Planning Application Response

Organisation:	Barnsley Council
Detail:	Demolition of existing non-motorised user (NMU) bridge and construction of replacement – over A633 Grange Lane, Stairfoot Barnsley
Planning Ref:	2025/1092
Link:	Application Details
Closing Date:	4 th July 2026
Response to:	MatthewMarsden@barnsley.gov.uk
Submitted by	Trans Pennine Trail National Office & Walk Wheel Cycle Trust
Date:	3 rd July 2026

Proposed Cross Sections

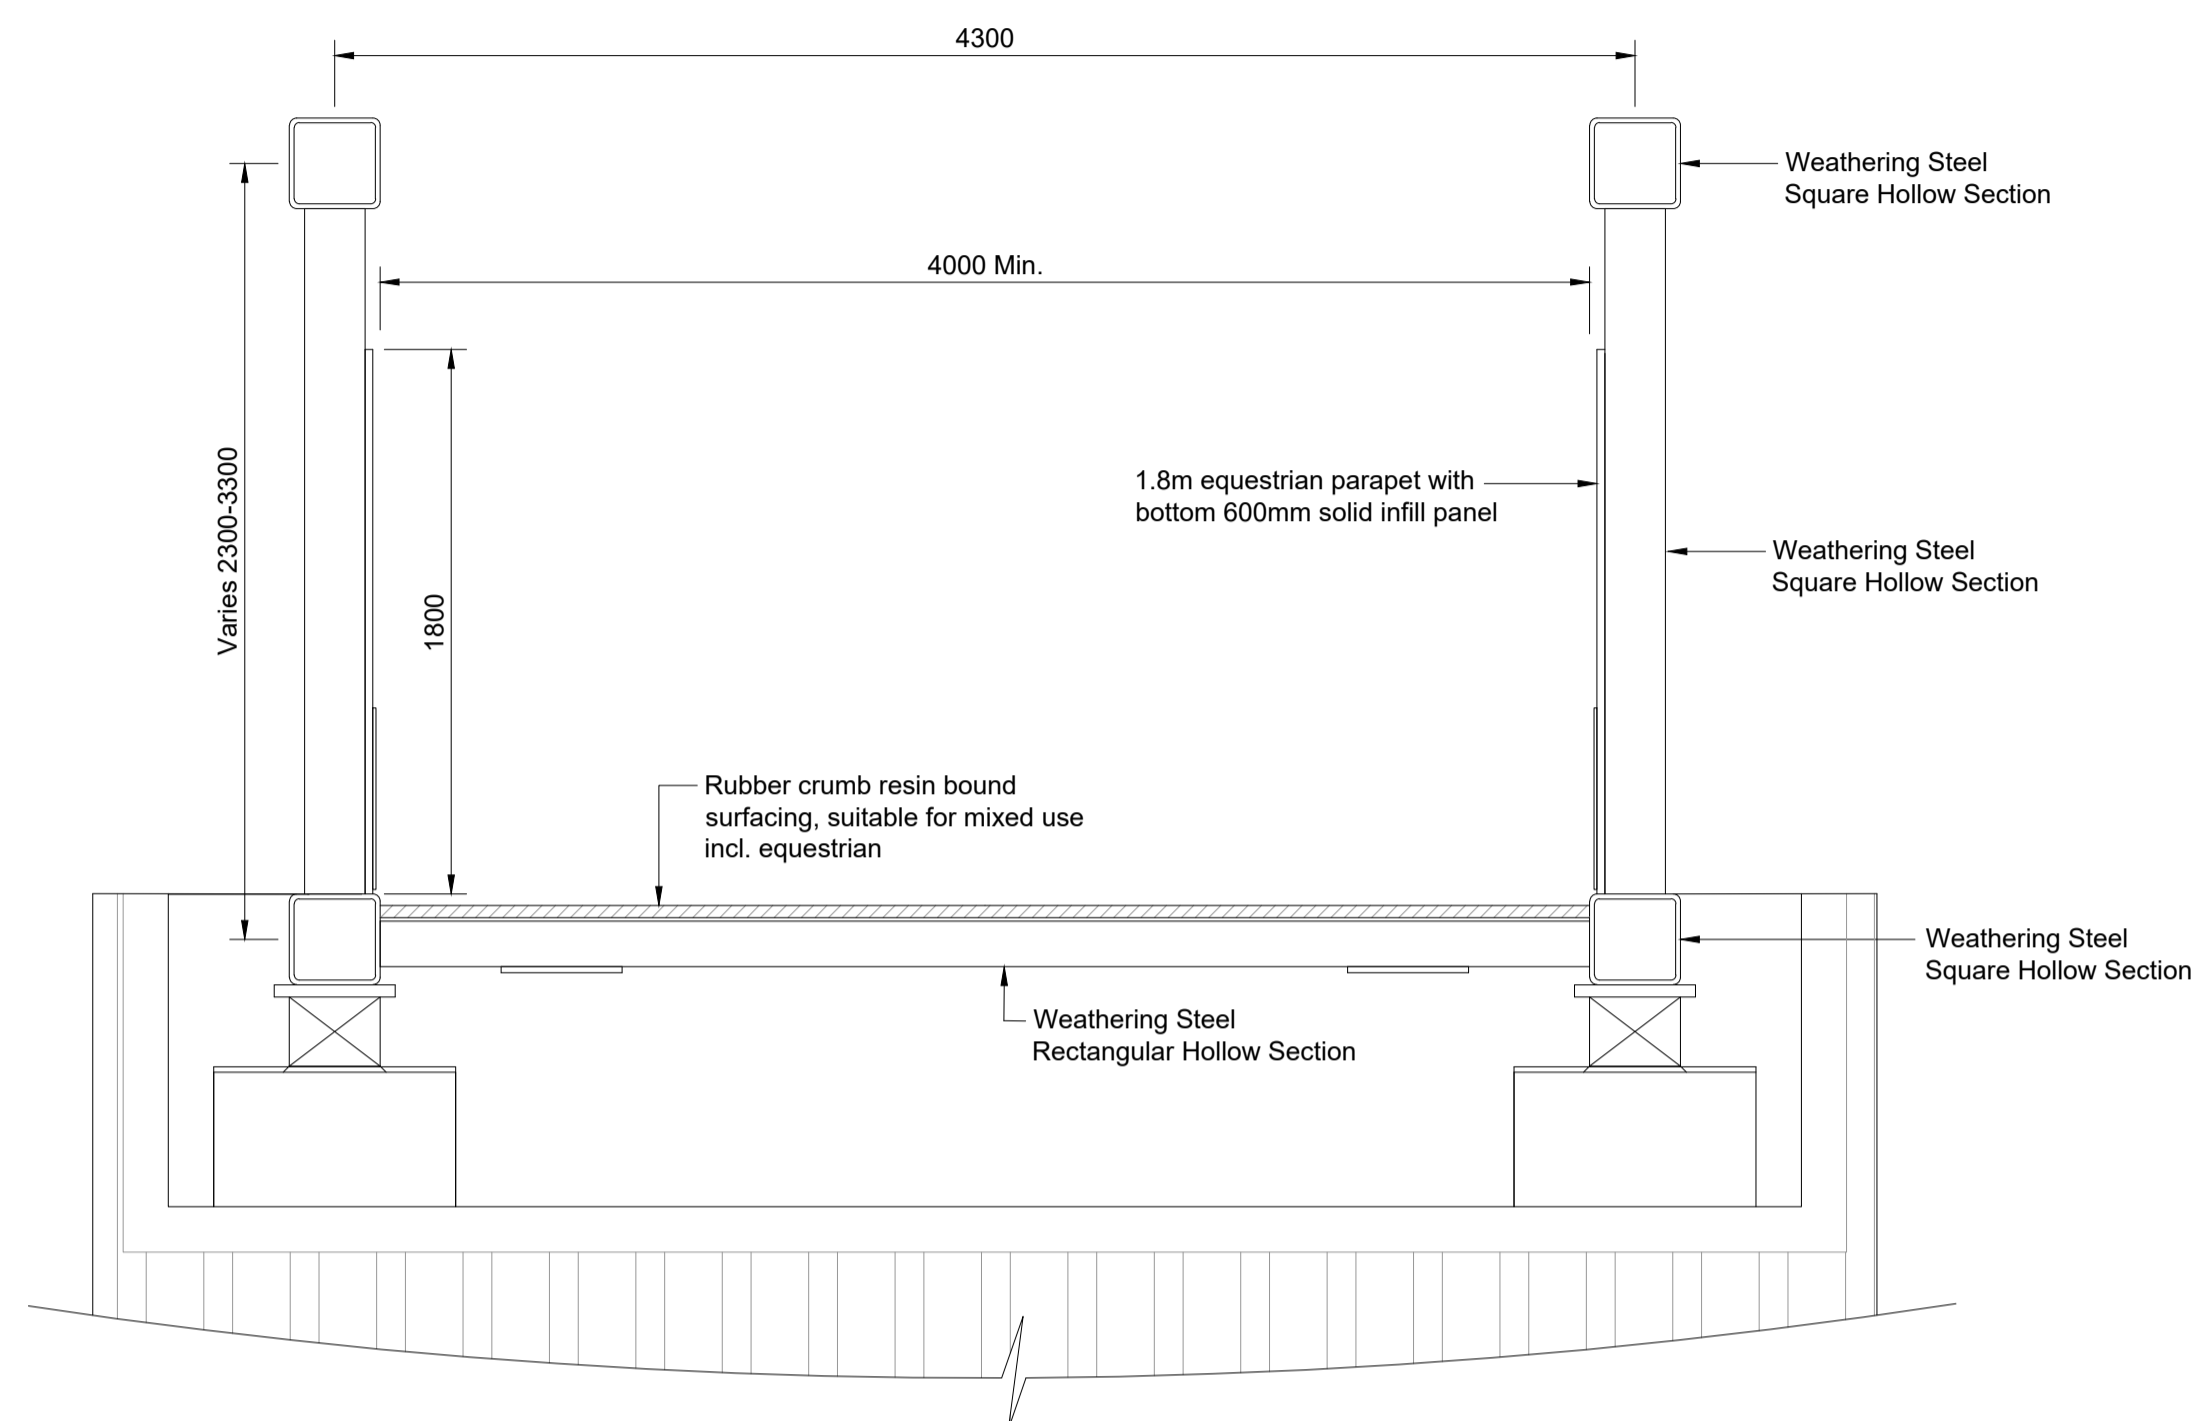
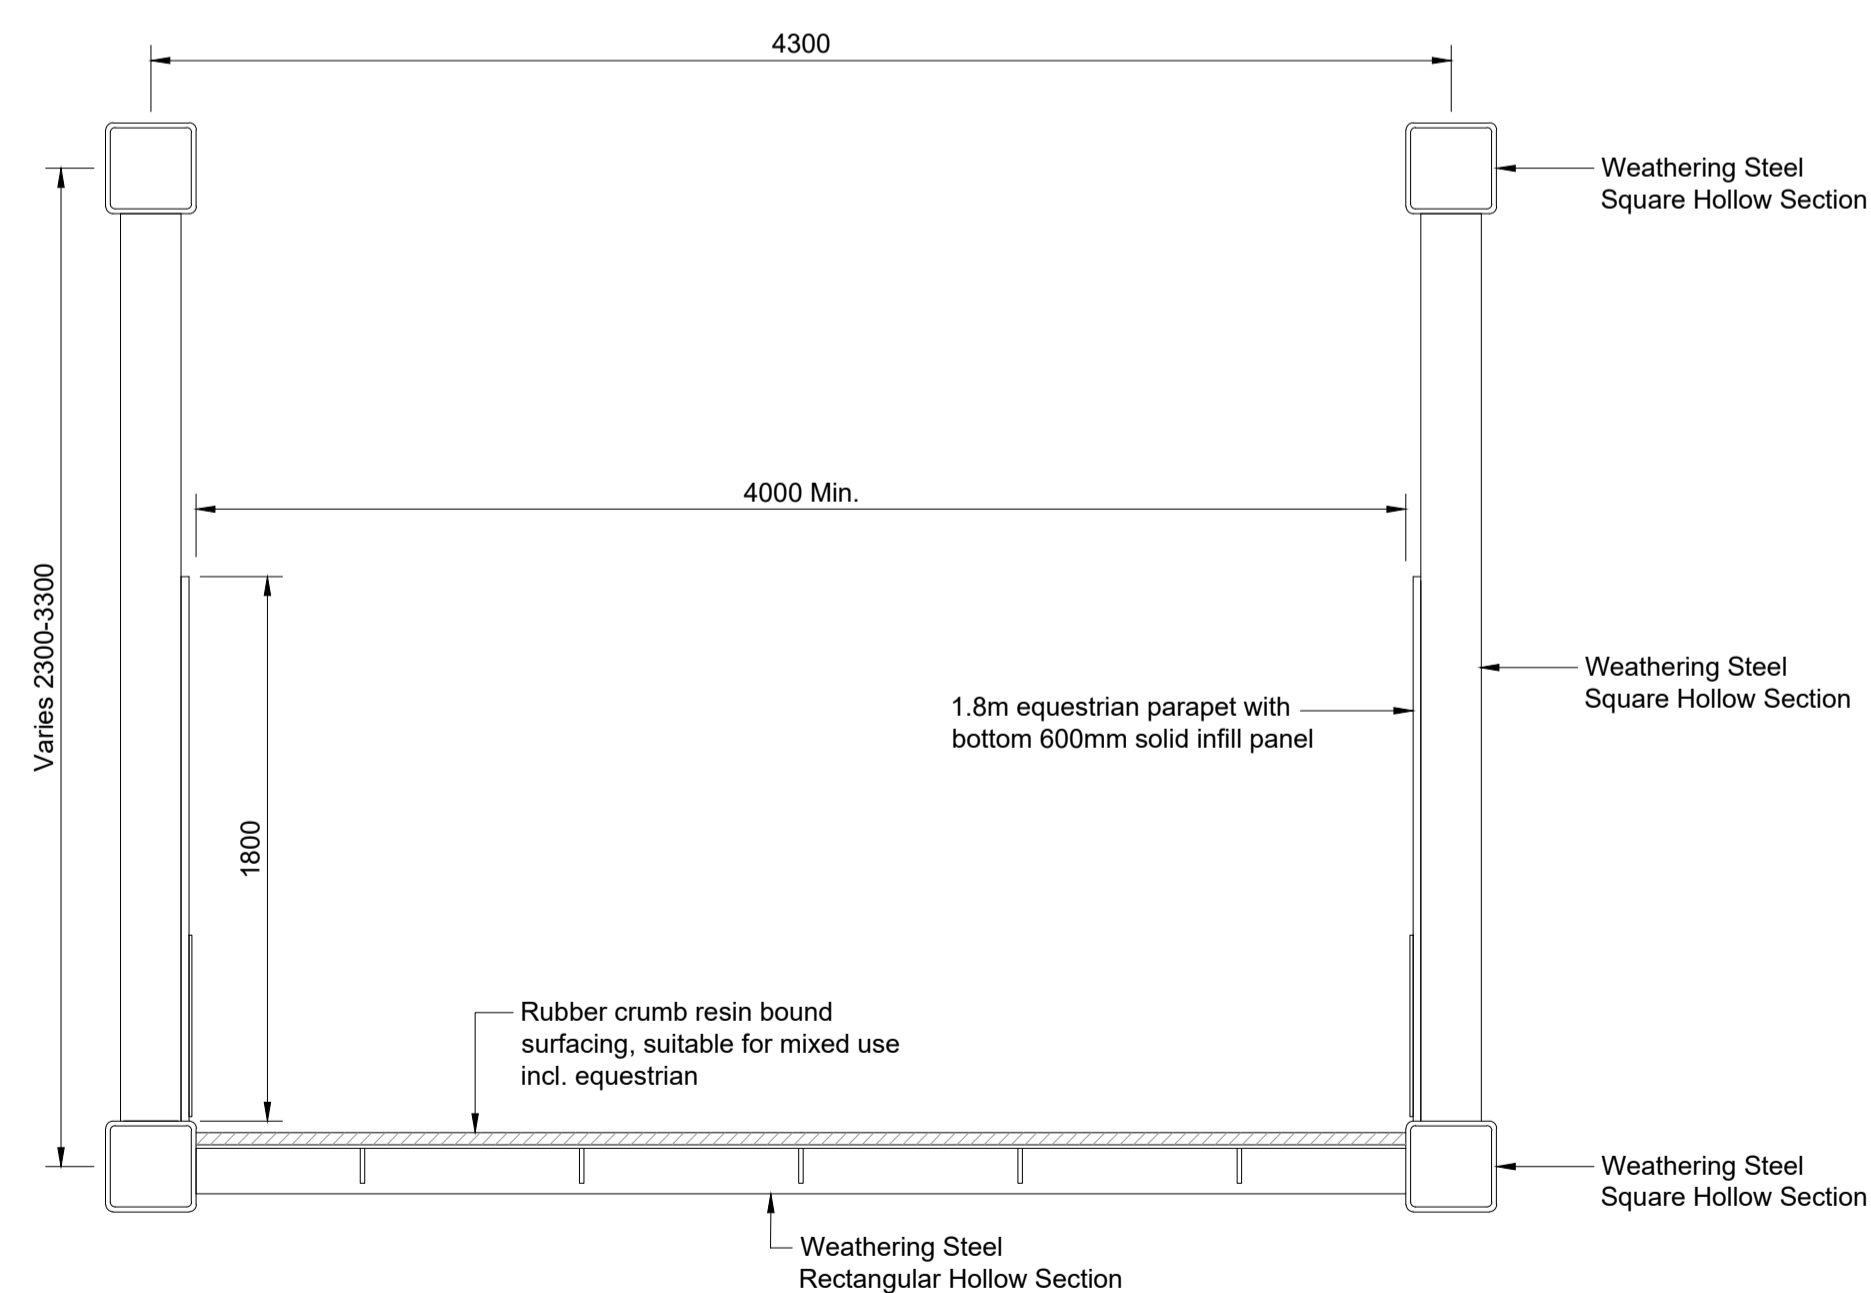
The new bridge will also need to support use for walkers, wheelers, horse riders and cyclists, as per existing structure, and therefore also meet requirements of the British Horse Society in terms of quality standards for surfacing and parapets for horse riders. It is also requested that the noise impact is taken into consideration for those users that are sensitive to loud noises – suggest advance notices are put on site. Mounting blocks should also be provided at each side of the bridge to allow riders the option of dismounting and walking their horse over the bridge.
